# CITY OF ALBUQUERQUE

June 7, 2017

RE: **ABQ Biopark Elephant Exhibit**  
**903 10<sup>th</sup> St SW**  
**Engineer's Stamp Date 6/2/17**  
**Hydrology File: K13D034B**

Based on the information provided in the submittal received on 6/5/17 the above-referenced Grading and Drainage Plan cannot be approved for building permit until the following are addressed:

GRADING &  
DRAINAGE  
PLAN

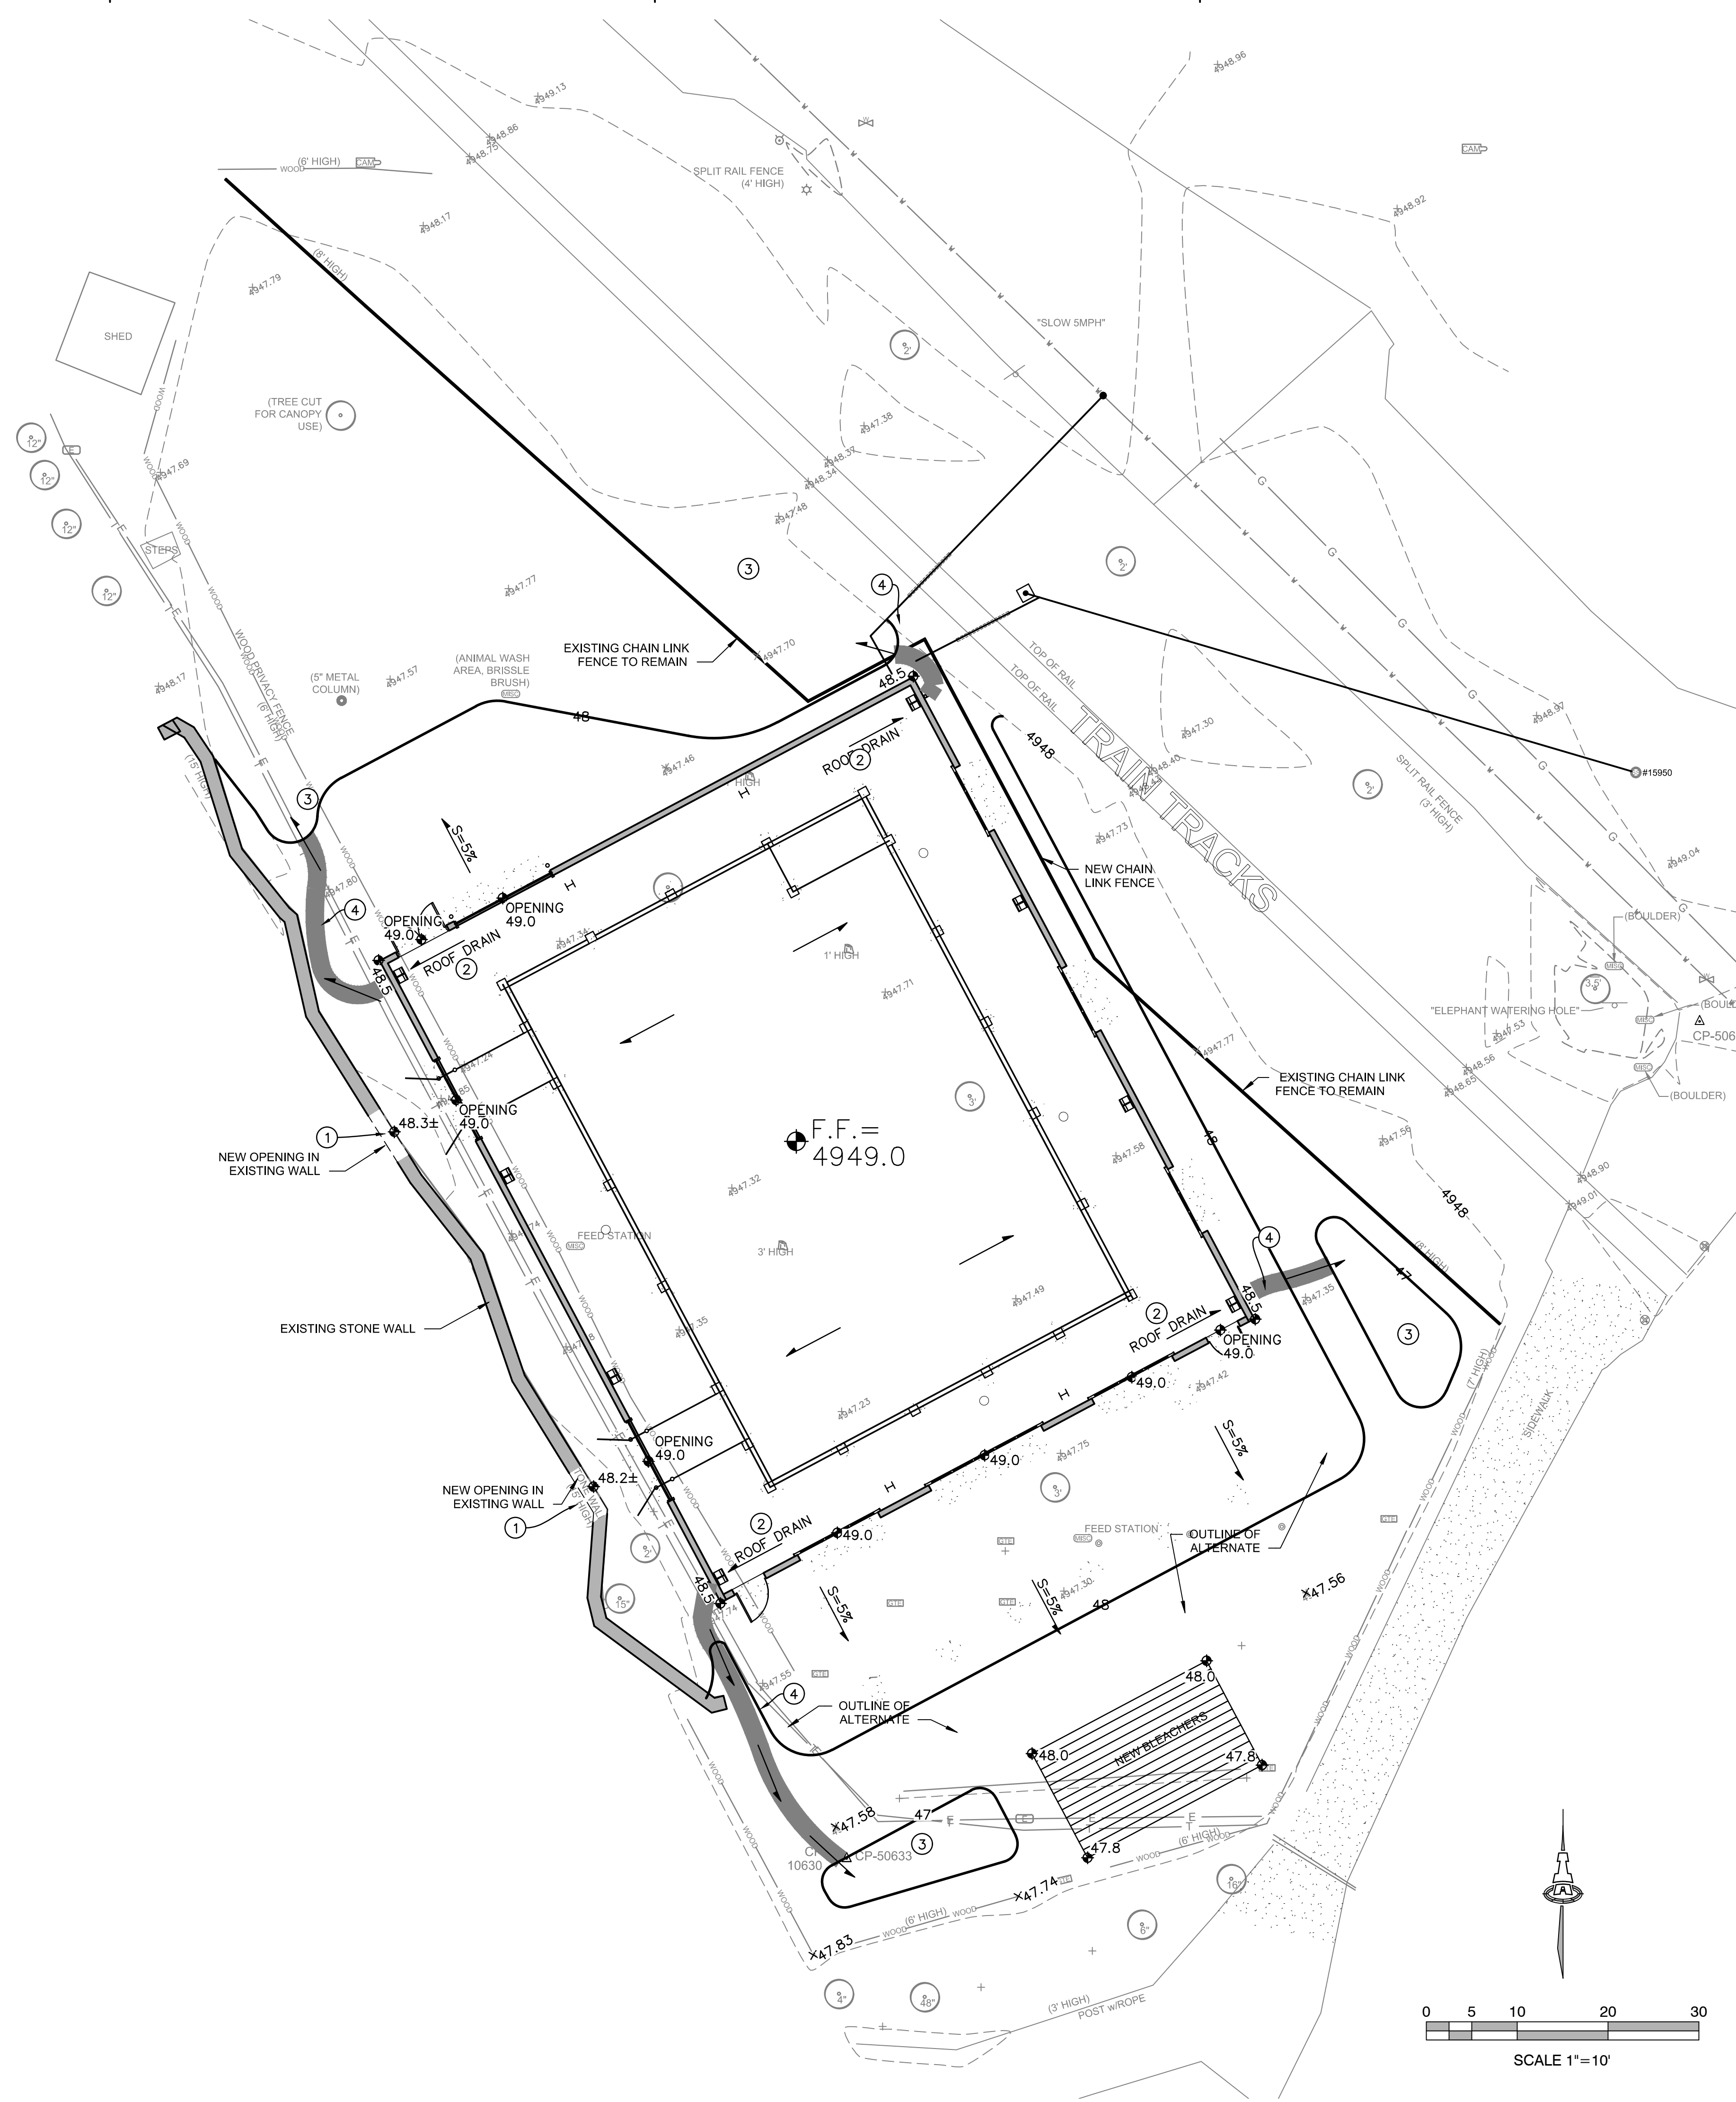
1. Developed flows must account for all offsite flows entering the enclosure and volume must be provided for the 100-yr, 10-day volume.
2. Provide the maximum water surface elevation for the 100-yr, 10-day volume.
3. The finished floor of the new elephant barn must be elevated at least 1' above the MWSE.
4. Expand the viewport to show surrounding contours and outbuildings potentially affected by the MWSE.
